1 December 2021

## **SECTION 4.55(1A) MODIFICATION APPLICATION - SSD-10375 PITT STREET NORTH OVER STATION DEVELOPMENT**

This section 4.55(1A) Modification Application has been prepared on behalf of Pitt Street Developer North Pty Ltd (**the Applicant**) to amend SSD-10375 which applies to the Pitt Street North Over Station Development Stage 2 (**PSN OSD**) at 252 Pitt Street, Sydney.

SSDA
GENERAL ARRANGEMENT PLAN
LEVEL 09

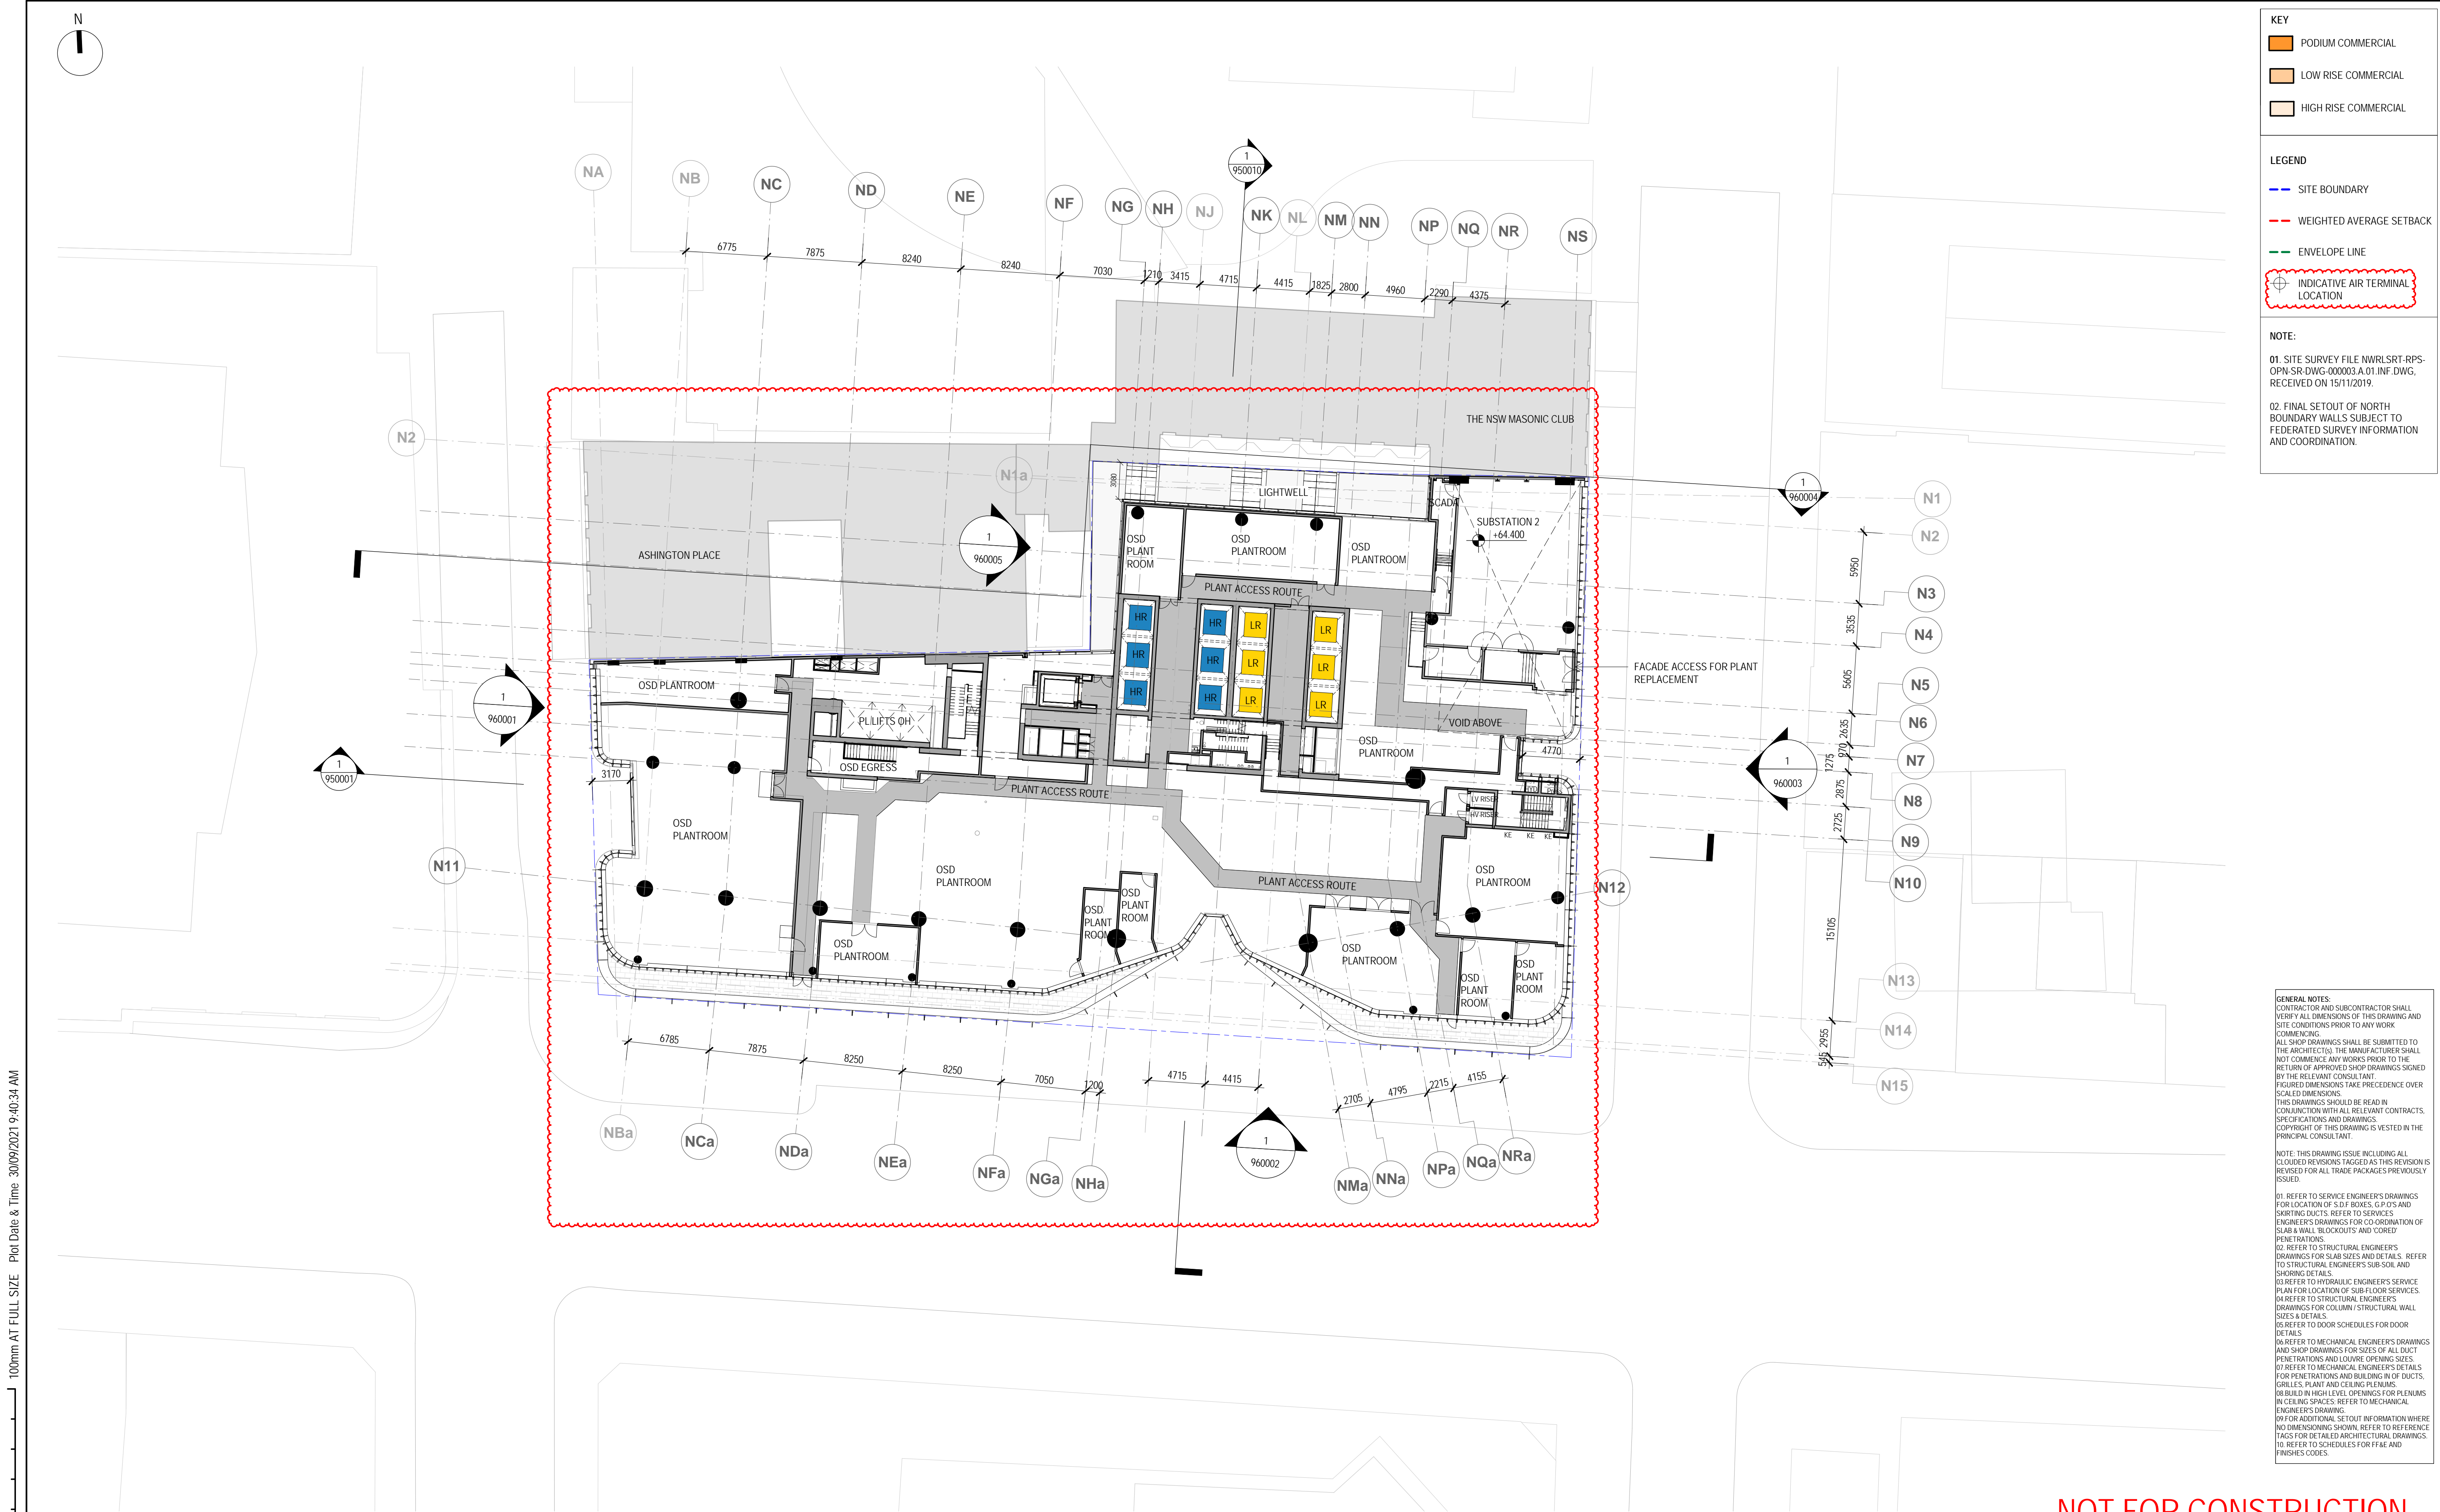
- Riser cupboard added near GL intersection NL and N7
  - Legend updated
- **Level 09** [SMCSWSPS-FOS-OSN-AT-DWG-930913]
  - Graphical corrections
  - Plant rooms added

PITT STREET INTEGRATED STATION DEVELOPMENT - OSN
SSDA
GENERAL ARRANGEMENT PLAN
LEVEL 36

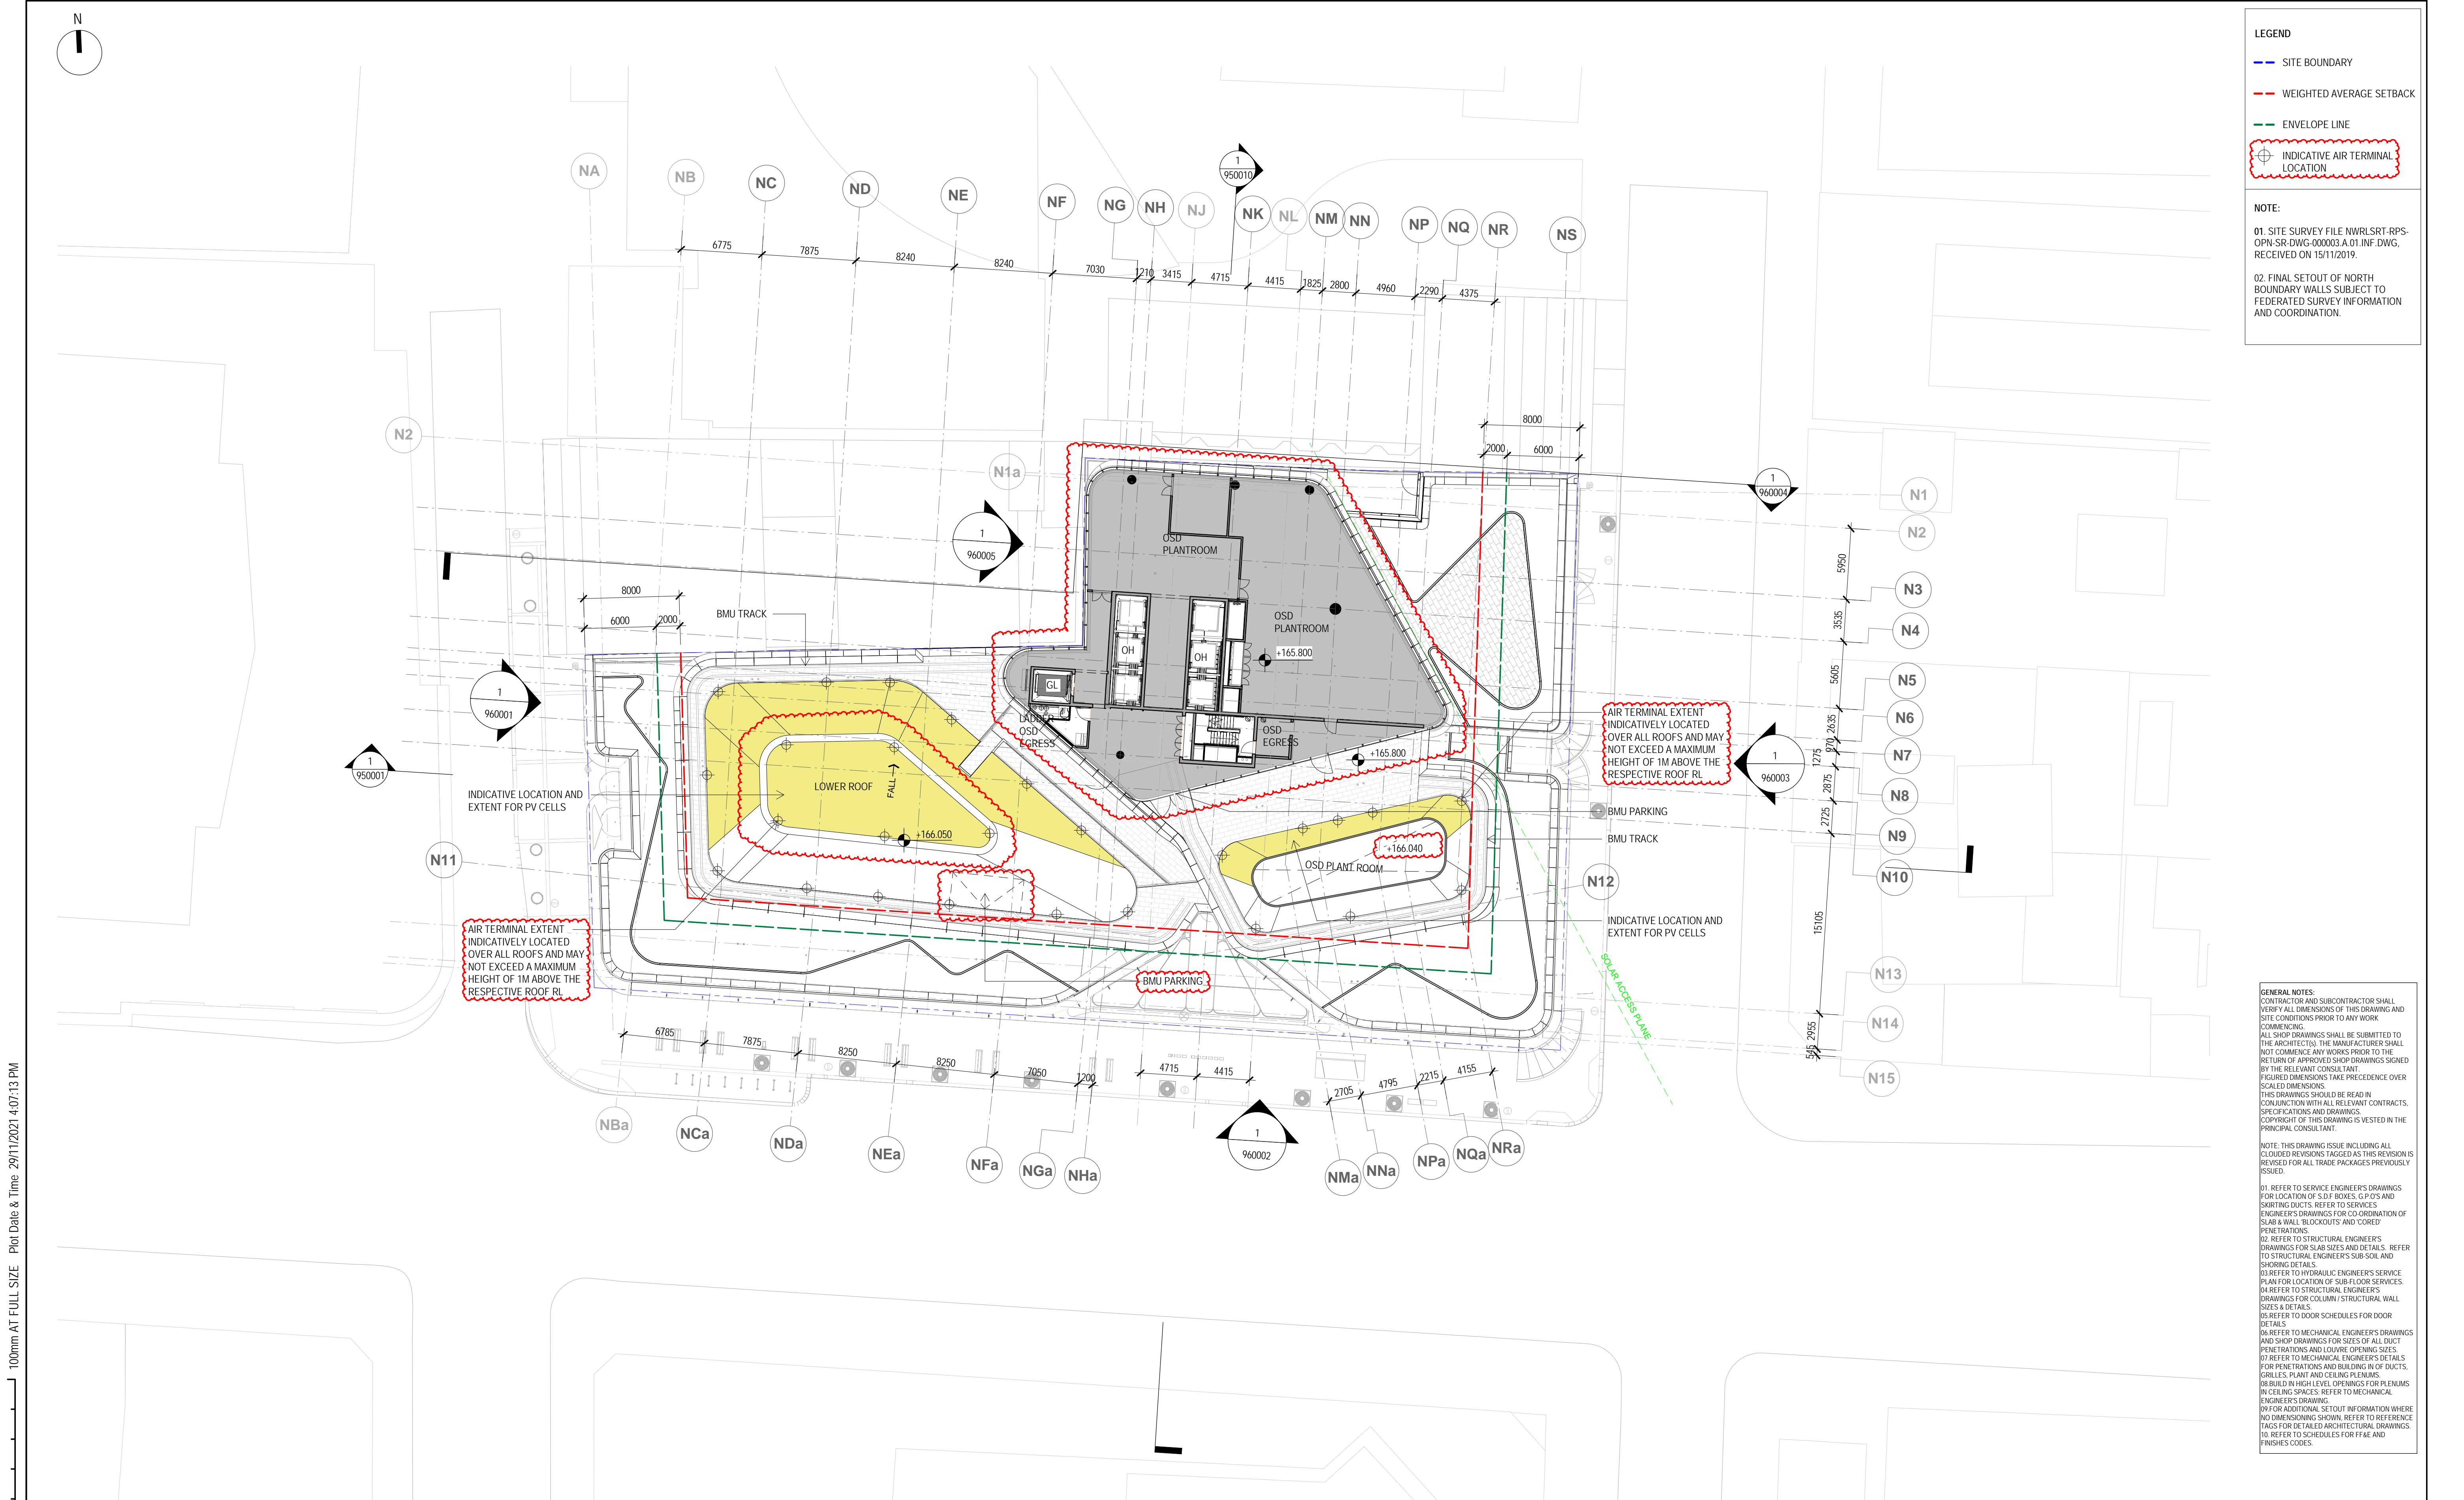
- Balustrade updated to translucent glazed balustrade between gridlines NN and NP along gridline N2
- **Level 36** [SMCSWSPS-FOS-OSN-AT-DWG-933613], **Level 37** [SMCSWSPS-FOS-OSN-AT-DWG-933713] and **Level 38** [SMCSWSPS-FOS-OSN-AT-DWG-933813]

SECTION B-B

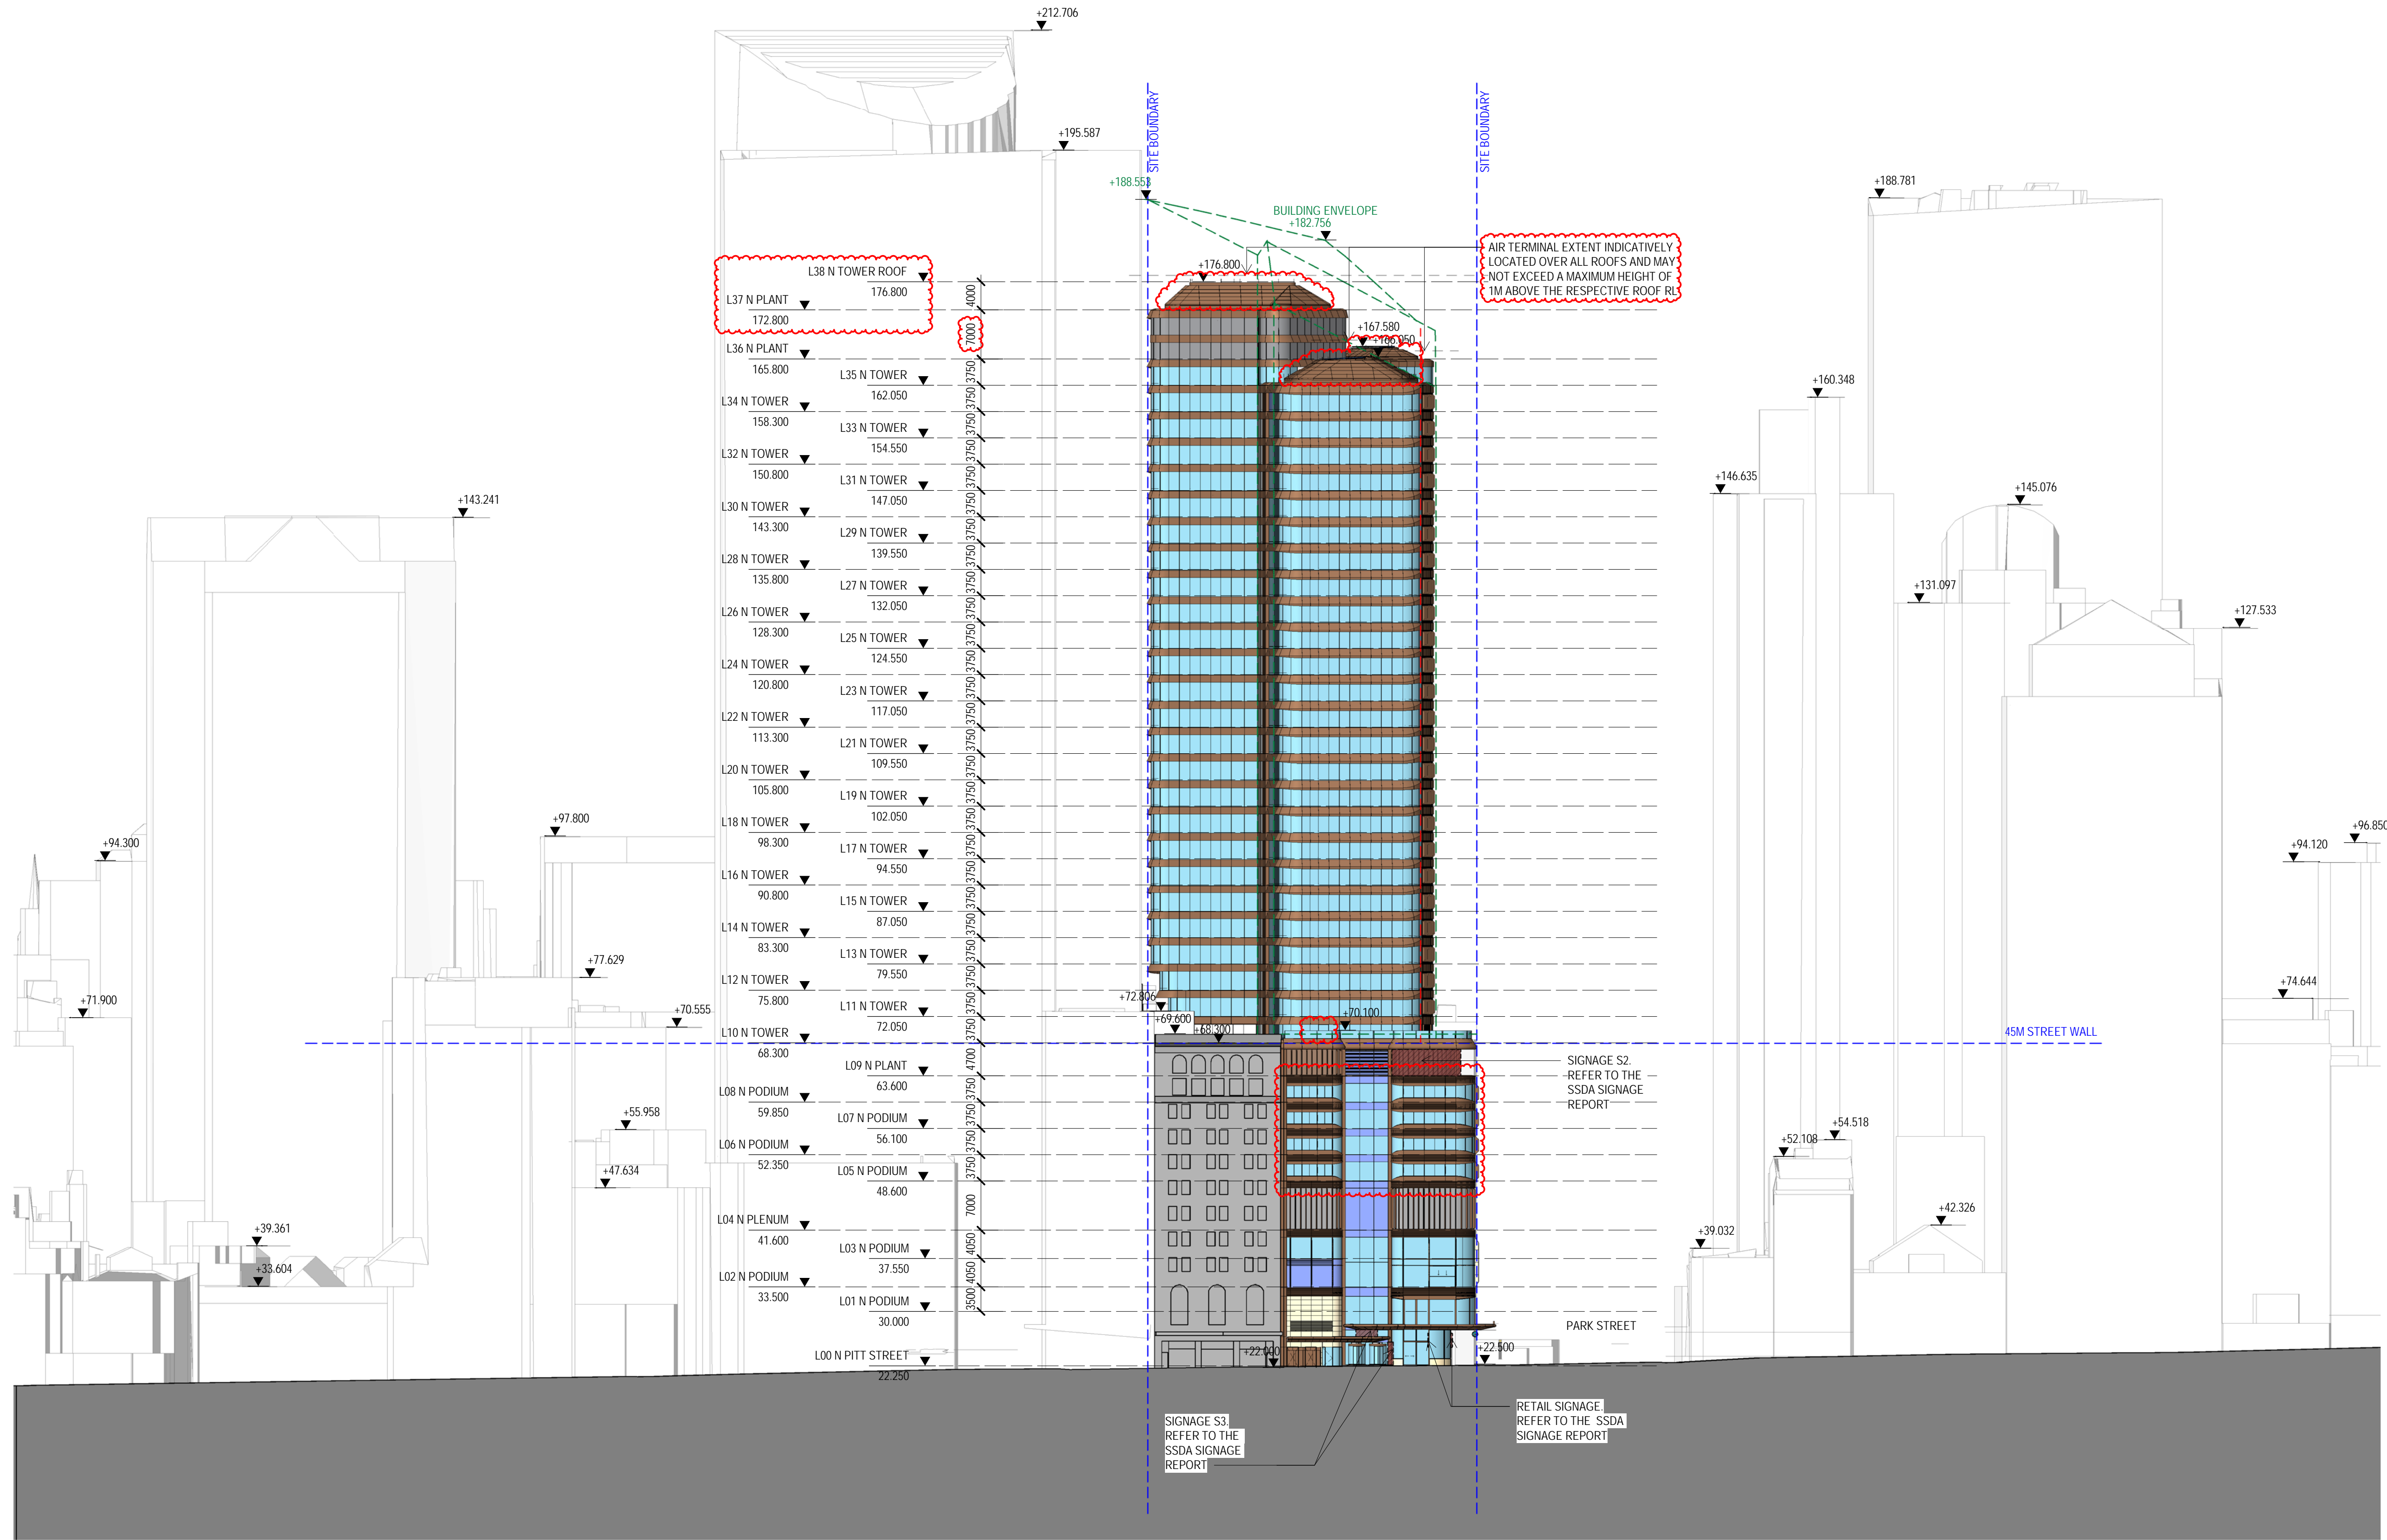
The Level 37 slab and plant rooms (detailed in SMCSWSPS-FOS-OSN-AT-DWG-933713) are proposed to be removed rendering this drawing sheet redundant. As illustrated in Section B-B in **Figure 16** this change results in a double level void but no external changes to the façade or height of the building.

As a consequence of removing the previous level 37, the upper levels of the tower and roof are renamed.
